Application for Removal or Variation of a Condition following Grant of Planning Permission or  
Listed Building Consent

Change of use of land for the siting of 6 timber glamping pods, erection of a reception hut and wood store, provision of parking/turning areas, footpaths (incl. footpath link to Hull Road) and cycle racks, with associated landscaping and pond

22/03028/PLF

4, 5, 13 , 20

Glamping pods and reception - Proposed finishes

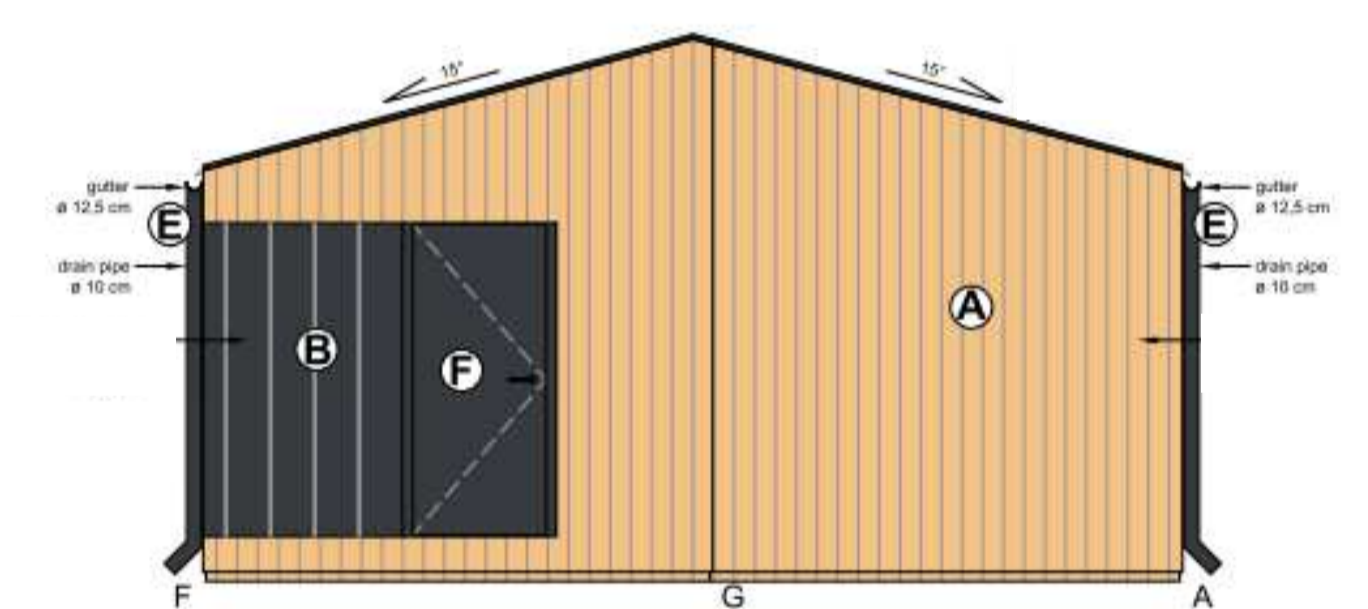
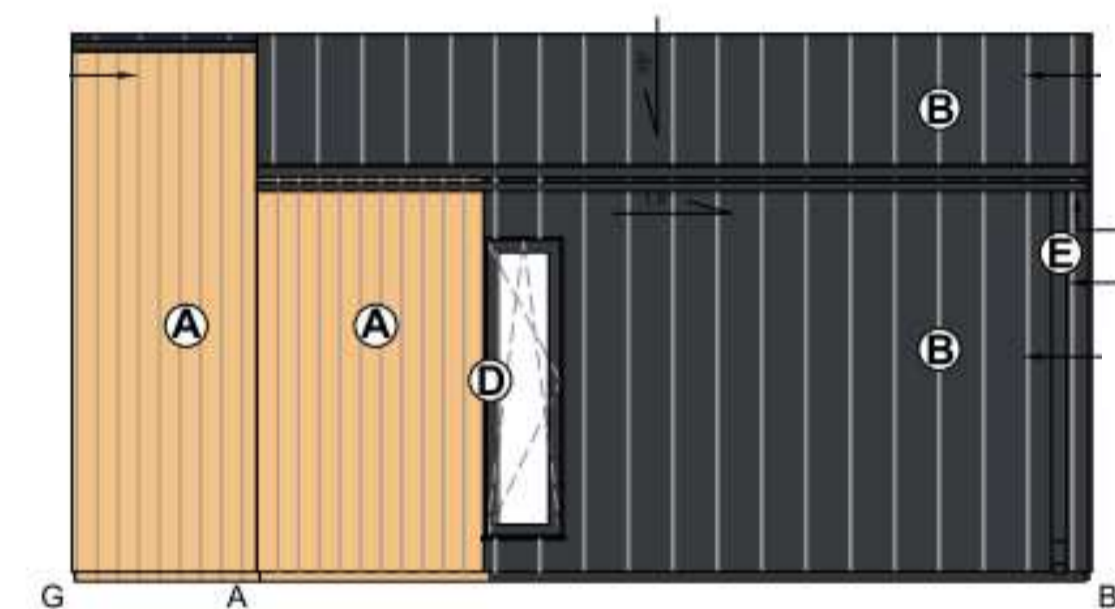
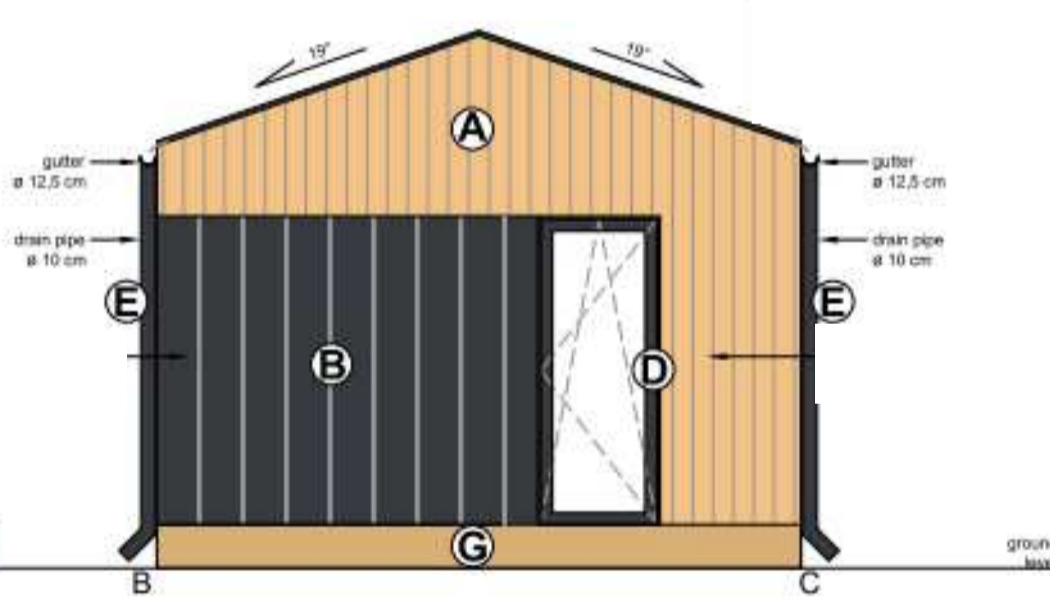
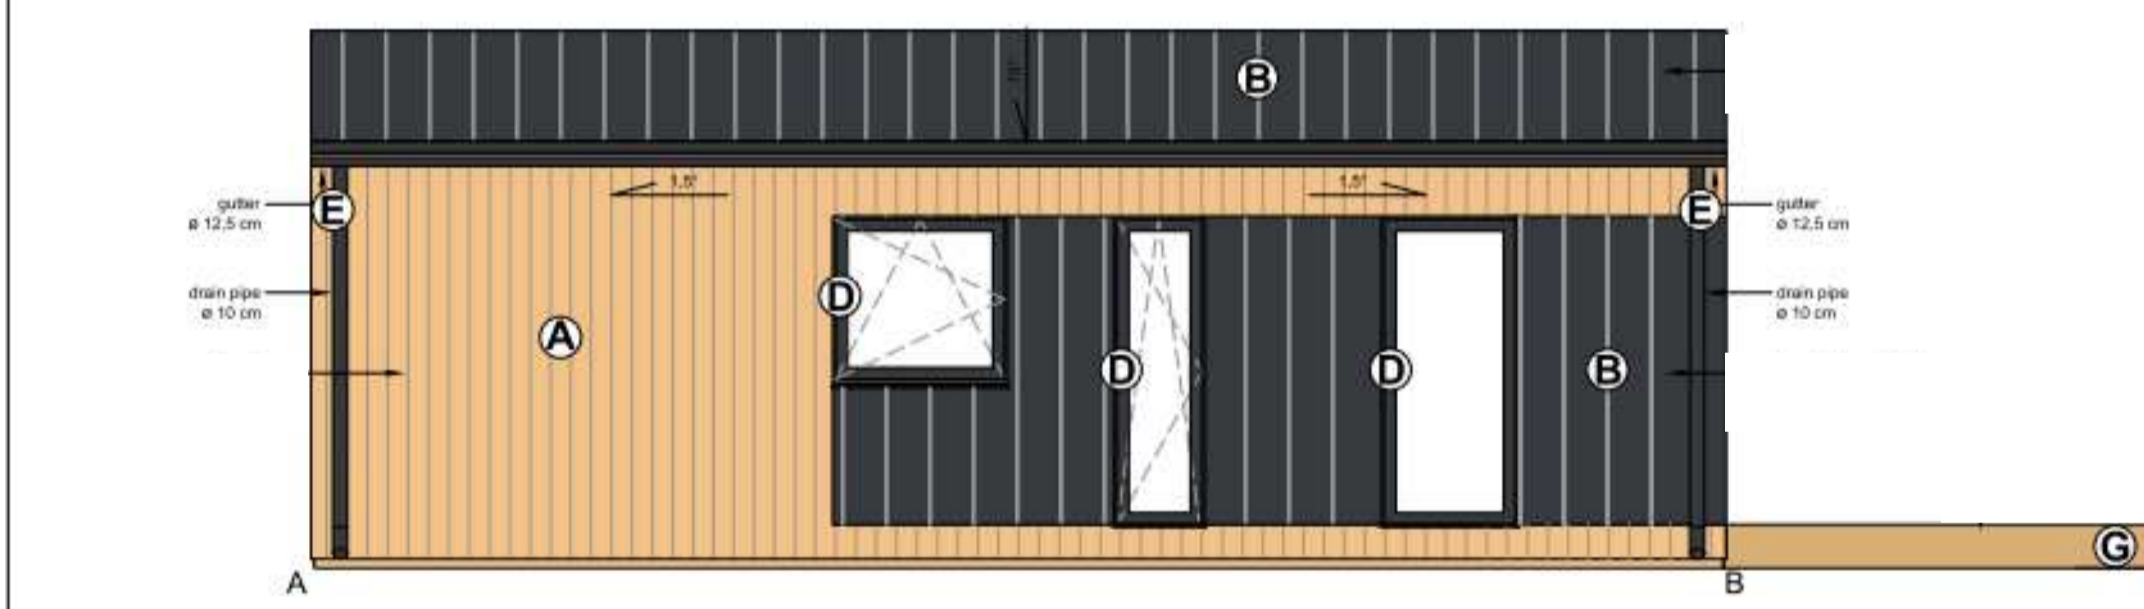
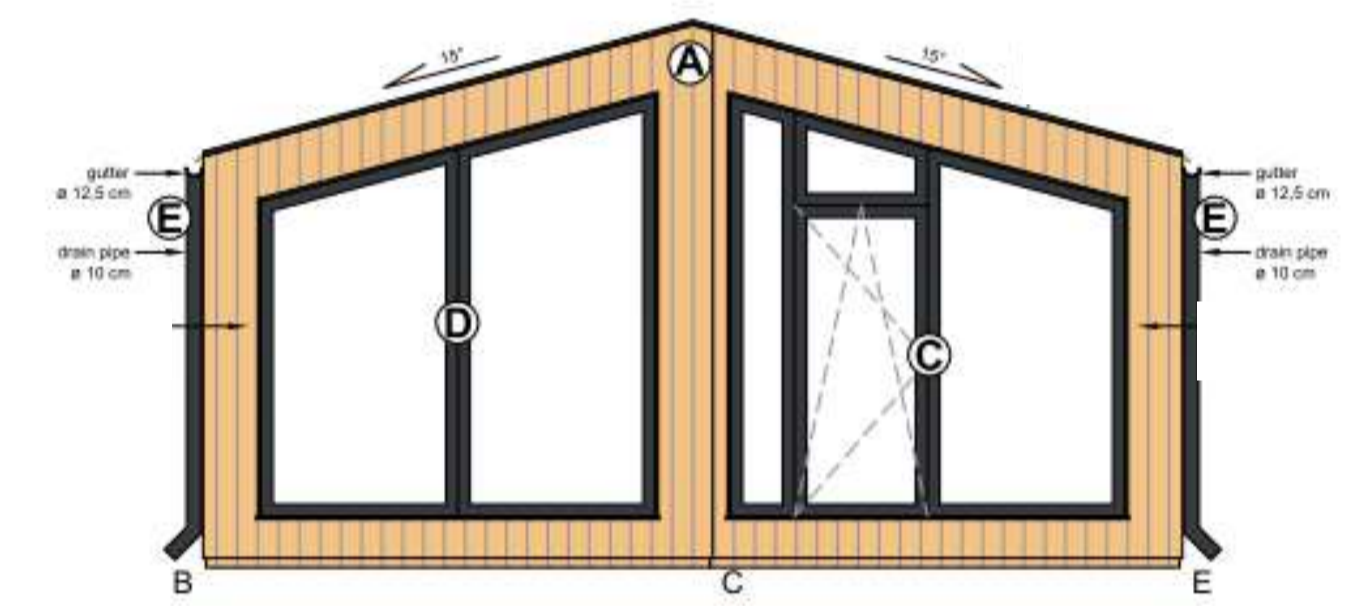
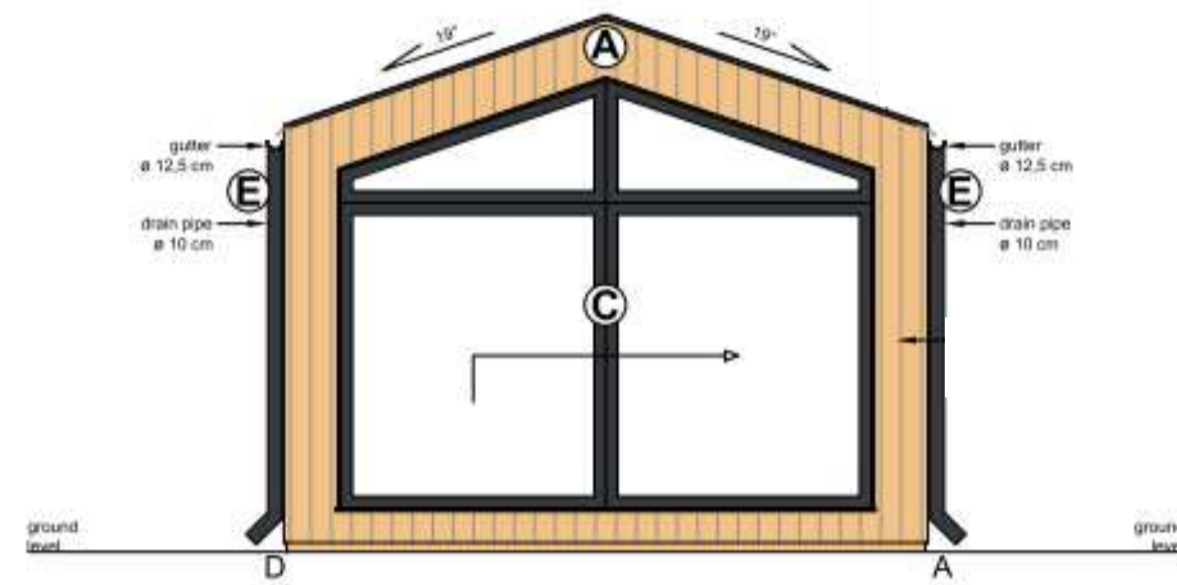
Conditions 4 & 5 - materiality details and other required information is to be submitted with this application hence will be deemed as discharged

**Drawing Title:**  
 ROAD AND ACCESS PLAN  
 rev C - tarmac naming changed - AS (MIU) 05/02/24  
 (note - changes made upon local authority's request to third party drawing hence architect takes no responsibility for the original information provided)

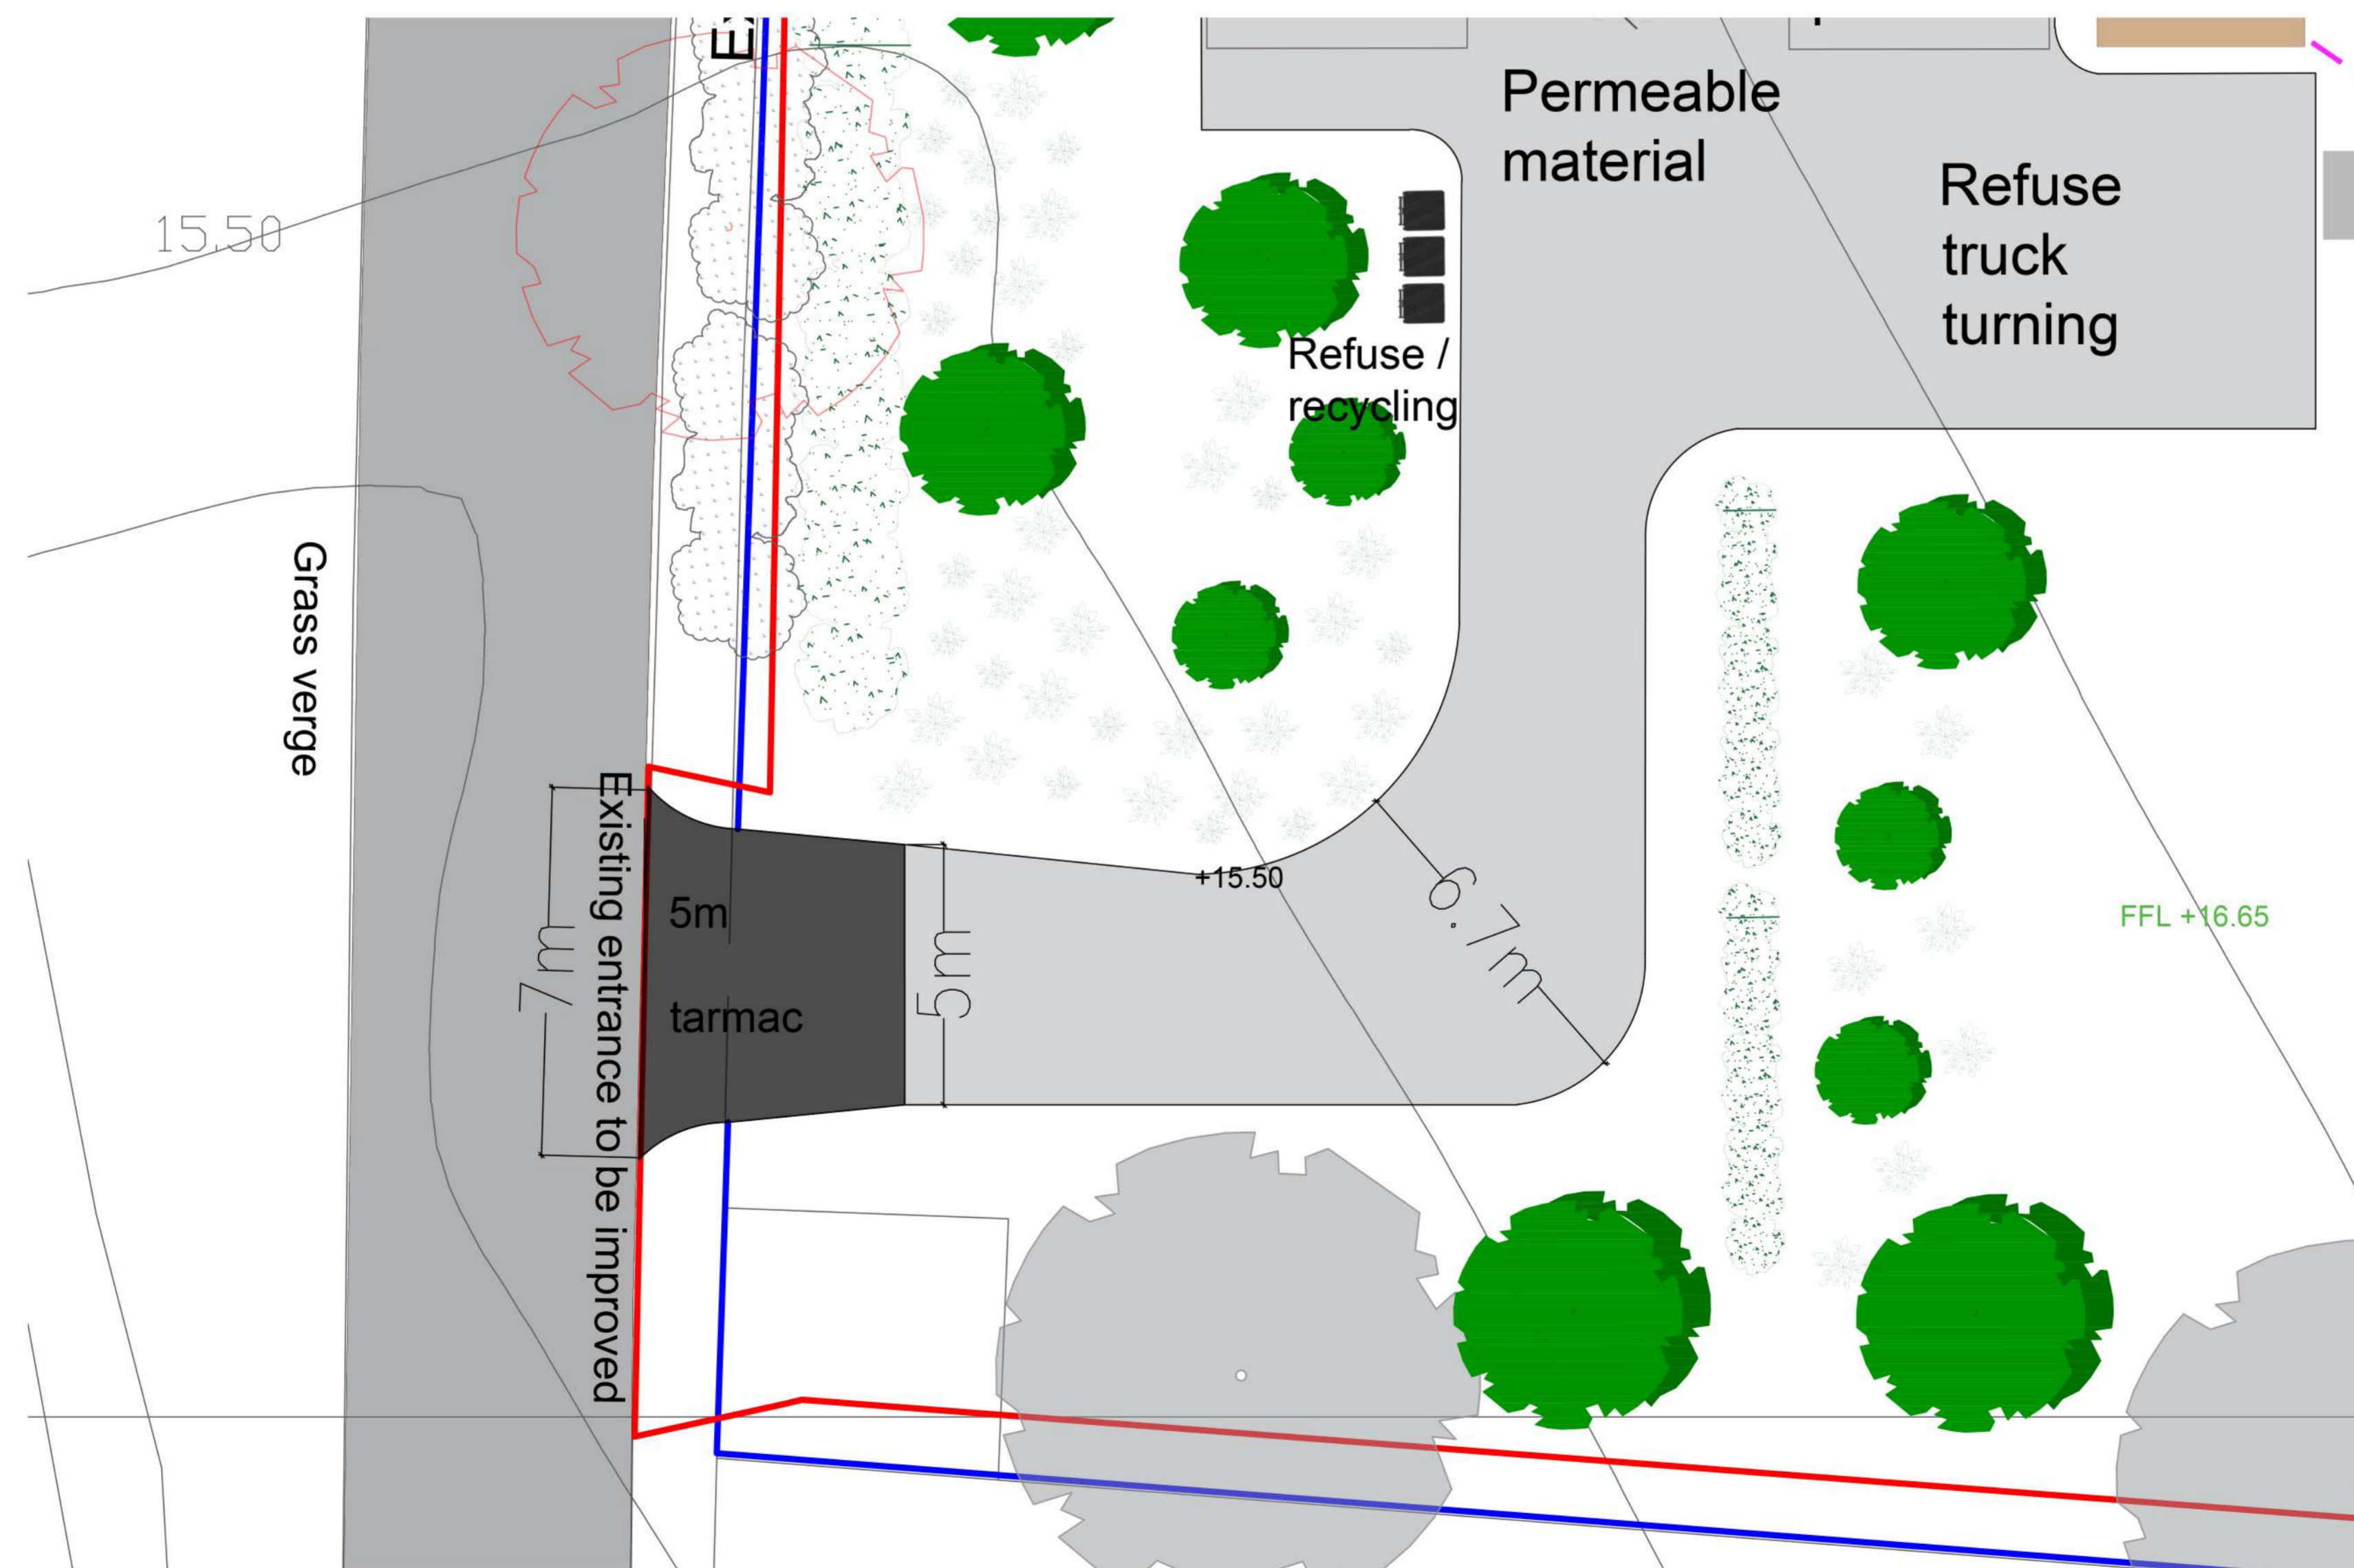
Condition 13 - all hard surfacing materials are to be submitted as part of this application. A section adjacent to road demarcated as "junction" is to be a traditional tarmac with drain instead of permeable tarmac to avoid hazards associated with deterioration of permeable tarmac.
